The SCOPING OPINION:

Proposed Teesside Flexible Regas Port

Case Reference: EN040001

22 April 2024

Figure 2.2
Indicative site allocation

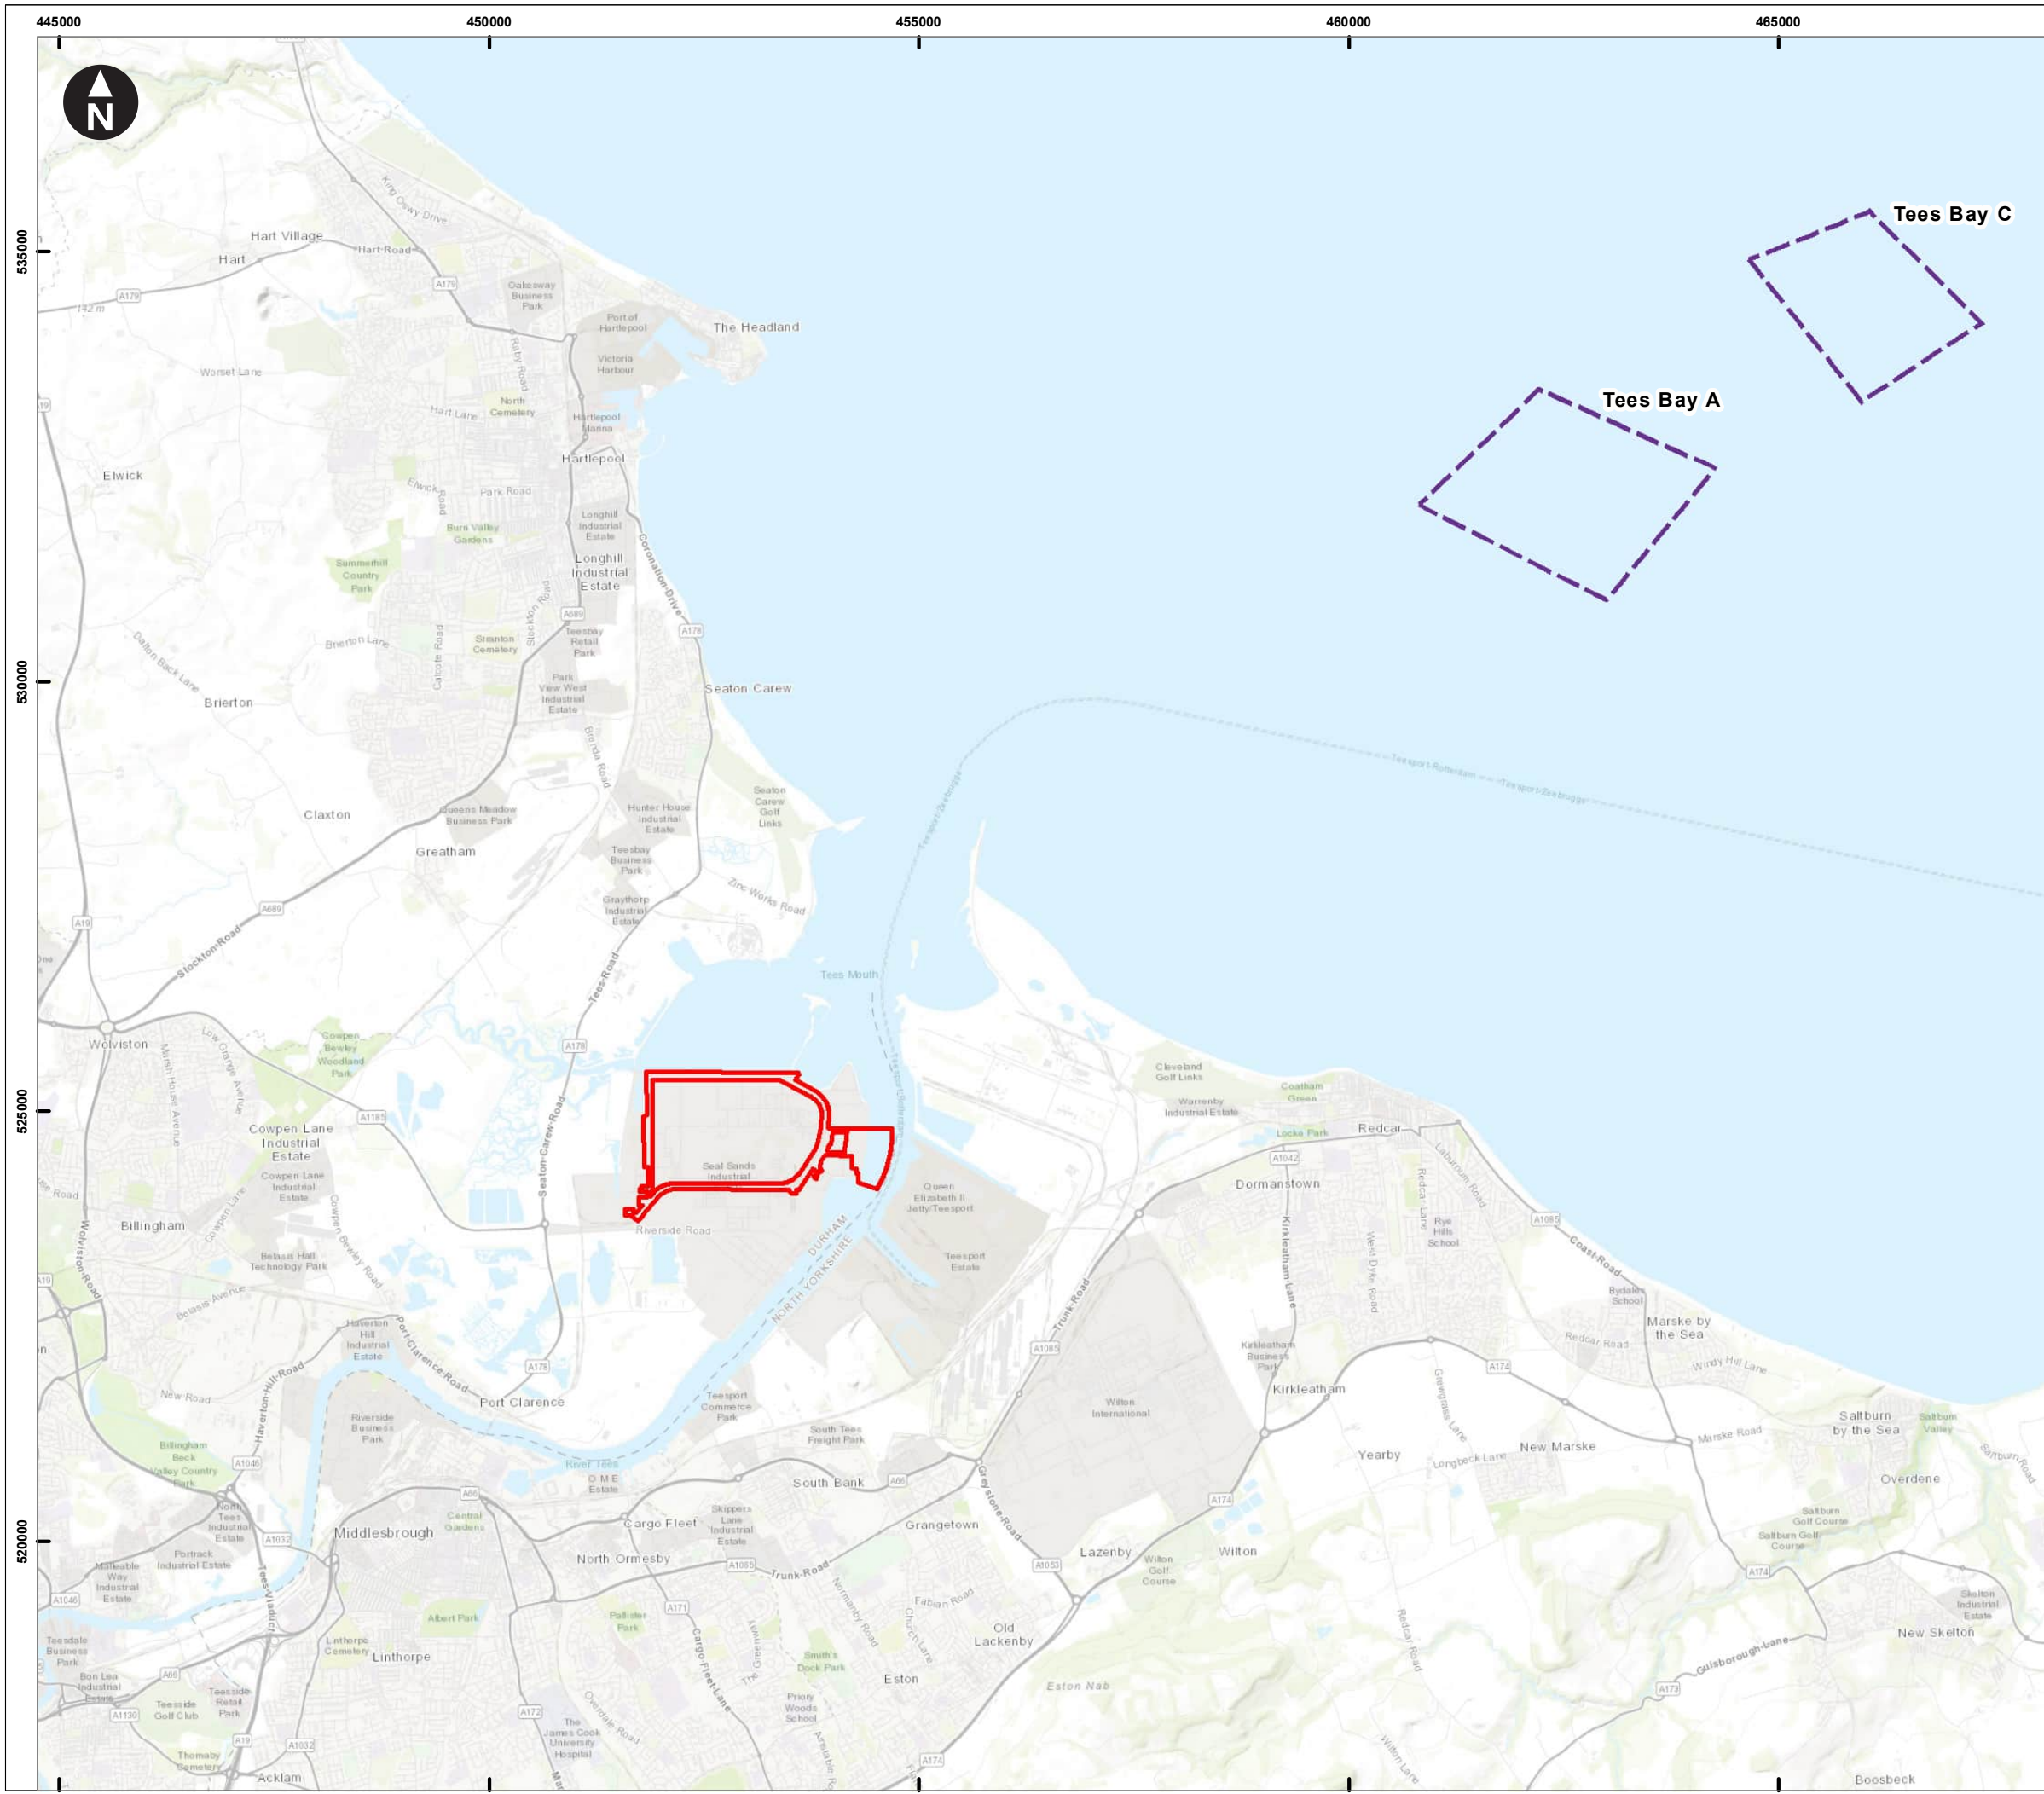
ID	Ref	Description	Inspectorate's comments
2.1.15	Figure 2.2	Indicative land use and justification for the order limits	<p>The indicative land use given in Figure 2.2 and graphic 2-2 does not show all of the elements of the Proposed Development, in particular:</p> <ul style="list-style-type: none"> • Figure 2-2 - the anticipated dredging areas and size of the jetty, both of which are indicated throughout the Scoping Report to be required to be capable of accommodating a known maximum size of vessel. • Figure 2-2 - The figure also contains terrestrial and marine areas that have no defined use at present, in particular the eastern extent of the boundary within the River Tees, and the area to the north of the regas facility. • Graphic 2-2 – The dimensions of the jetty, indicative dredged area and indicative dredged pocket is not shown on this figure, despite maximum extents or requirements being defined throughout the Scoping Report. • Graphic 2-2 also does not define the difference between the dredged pocket and dredged channel, or provide a justification for the size and shape of these (for example the exclusion of the 2 lighter shaded triangles above the proposed new channel line, inclusion of areas above the hatched white line adjacent to the jetty and the dredged pocket appearing to be represented as a deeper channel than the dredged area despite the moorings being within the dredged area). <p>As such, it is currently unclear as to the anticipated layout of the Proposed Development, and the requirement for the current size of the order limits. The ES should present the anticipated land use and parameters on an appropriate figure and include all aspects of the Proposed Development in relevant ES figures and accompanying application documents.</p>

Figure 7.2a
Statutory designated sites

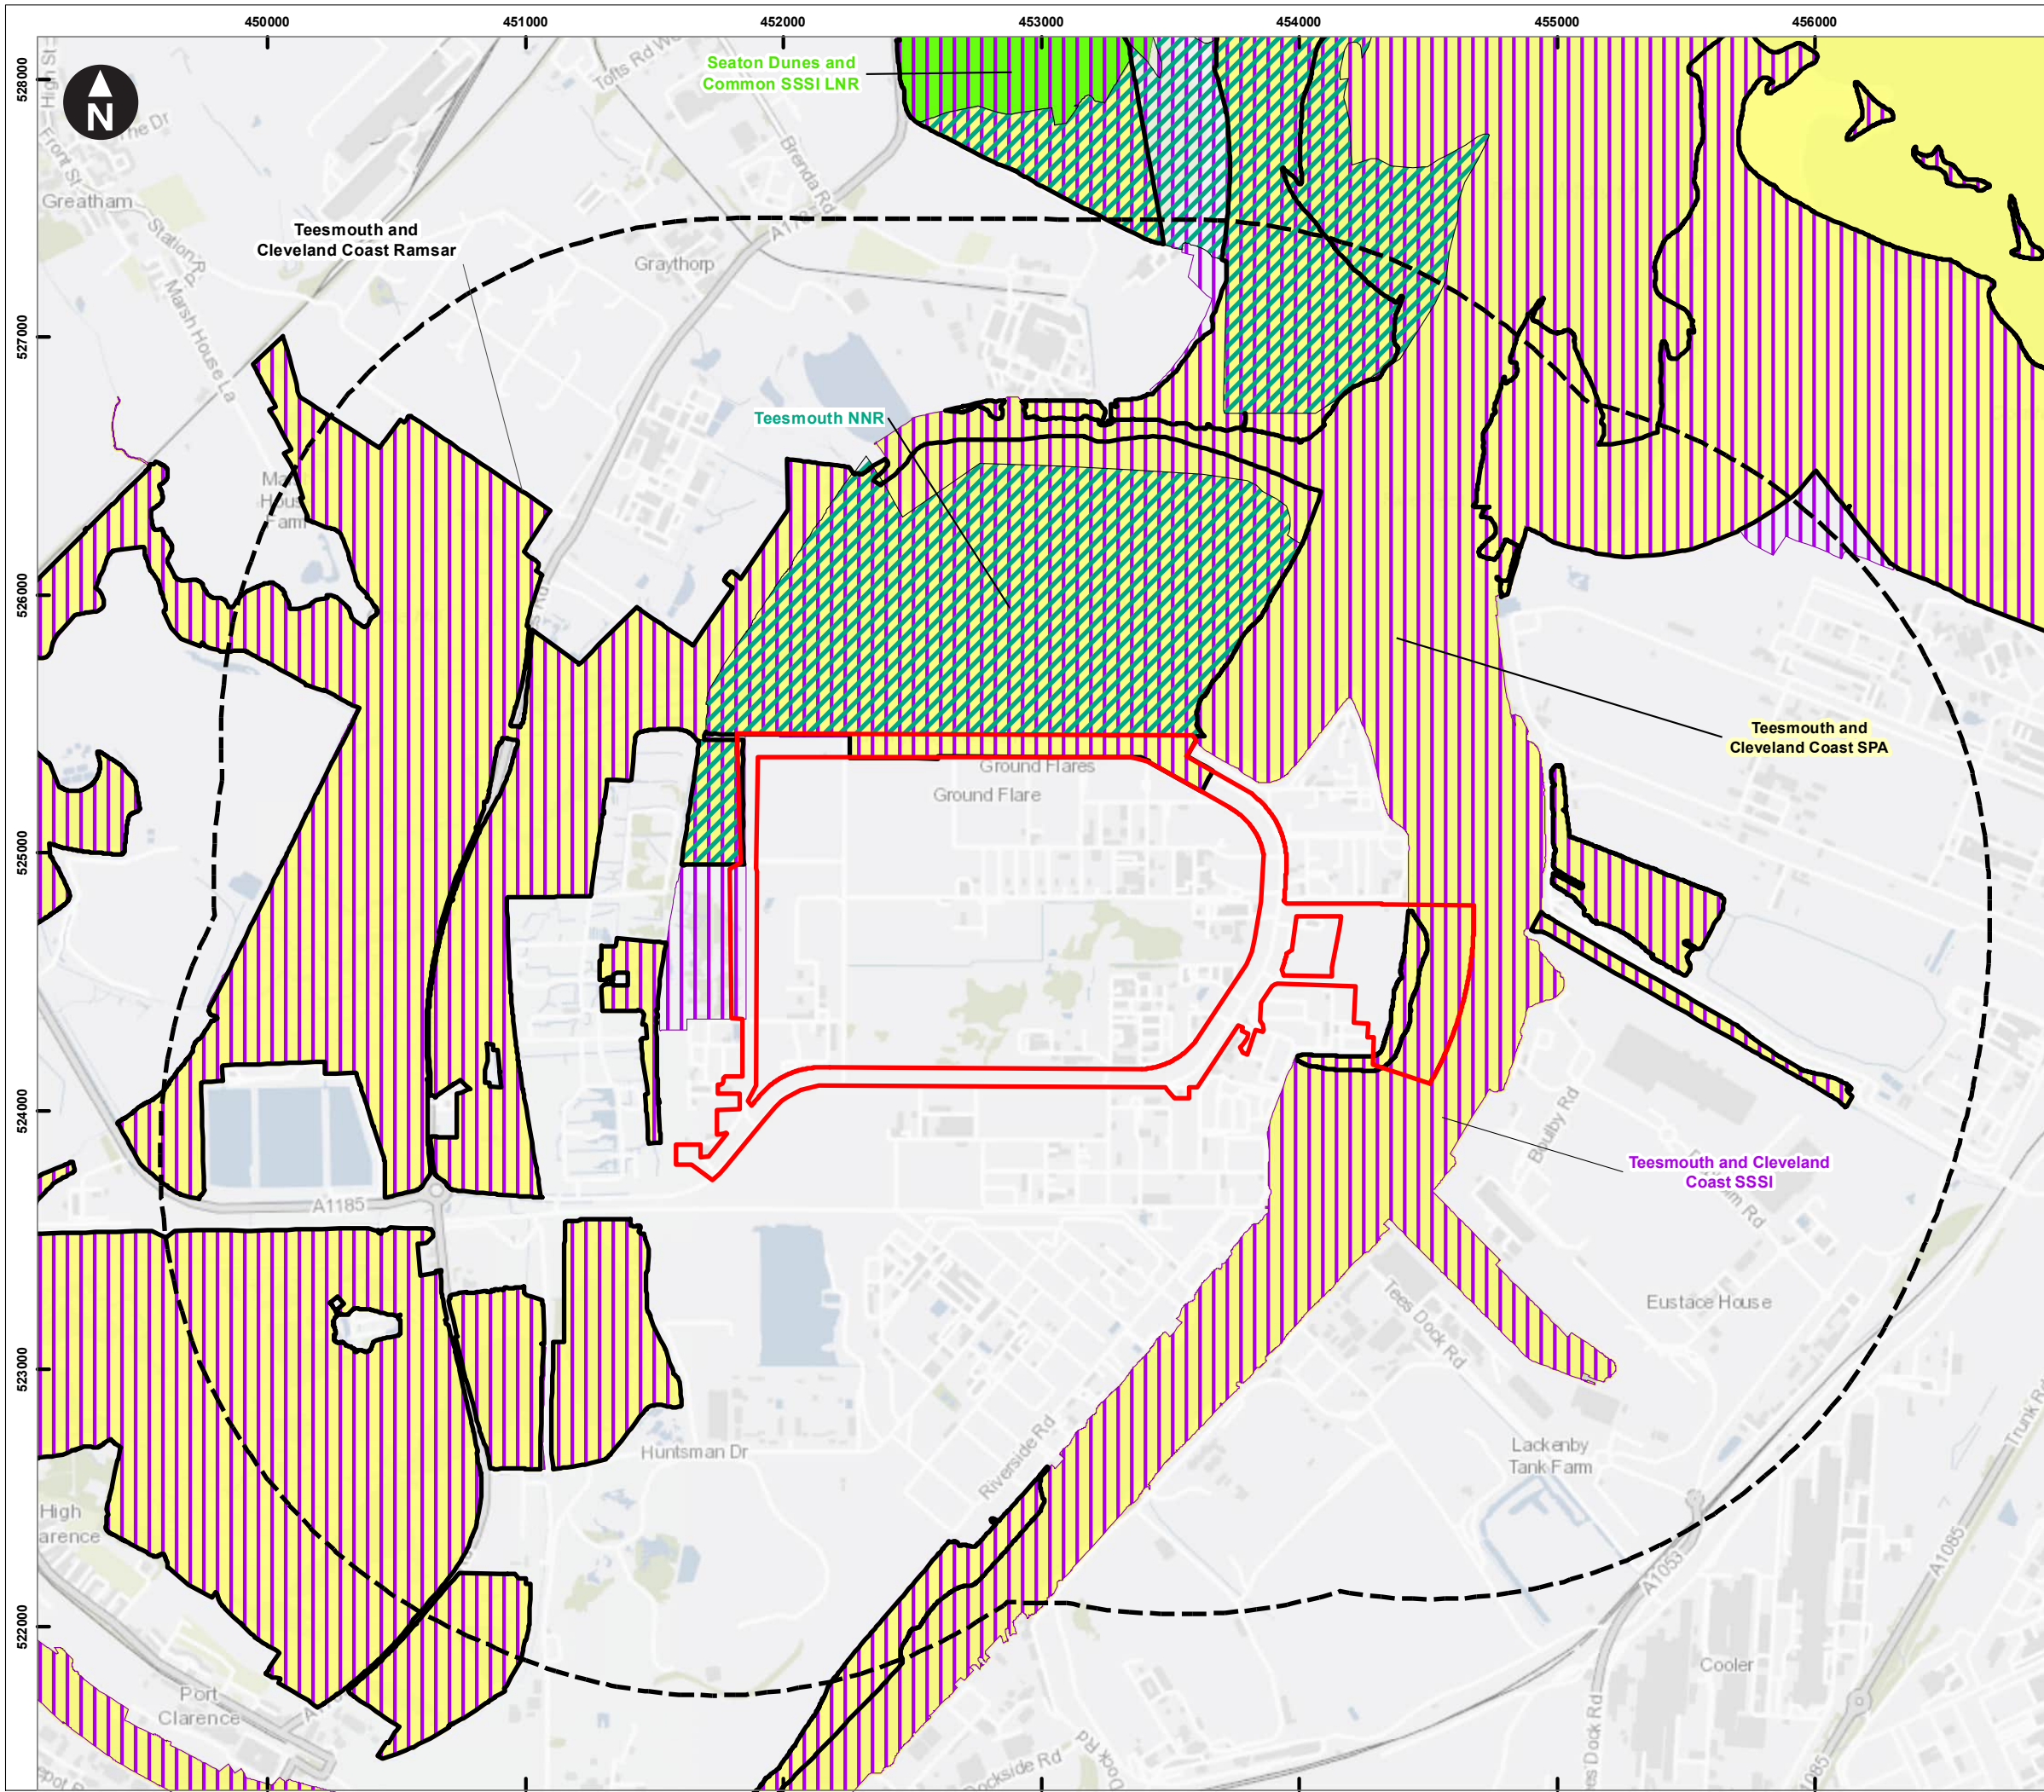
ID	Ref	Description	Inspectorate's comments
3.1.5	5.6.1 and Figure 7.2a	Sensitive receptors	The study area for the operational phase is stated to extend out to 10km from the Proposed Development. Paragraph 5.6.1 lists sensitive receptors identified as being relevant to the air quality assessment. Figure 7.2a shows designated sites within a 10km radius of the

ID	Ref	Description	Inspectorate's comments
	and Figure 7.3		Proposed Development, but not all the sites shown on Figure 7.2a are listed in paragraph 5.6.1. Likewise, Figure 7.3 shows non statutory designated sites which are not listed in paragraph 5.6.1. The ES should present a justification for any ecological sites within the study area that are excluded from the assessment based on relevant guidance. This should be done in consultation with the relevant consultation bodies.
3.1.6	N/A	Study area and location of sensitive receptors	The air quality figure provided within the Scoping Report (Figure 5.1) shows the location of monitoring locations. The ES should also contain a figure to identify the study area used for the air quality assessment, which includes the sensitive receptors identified for the assessment.
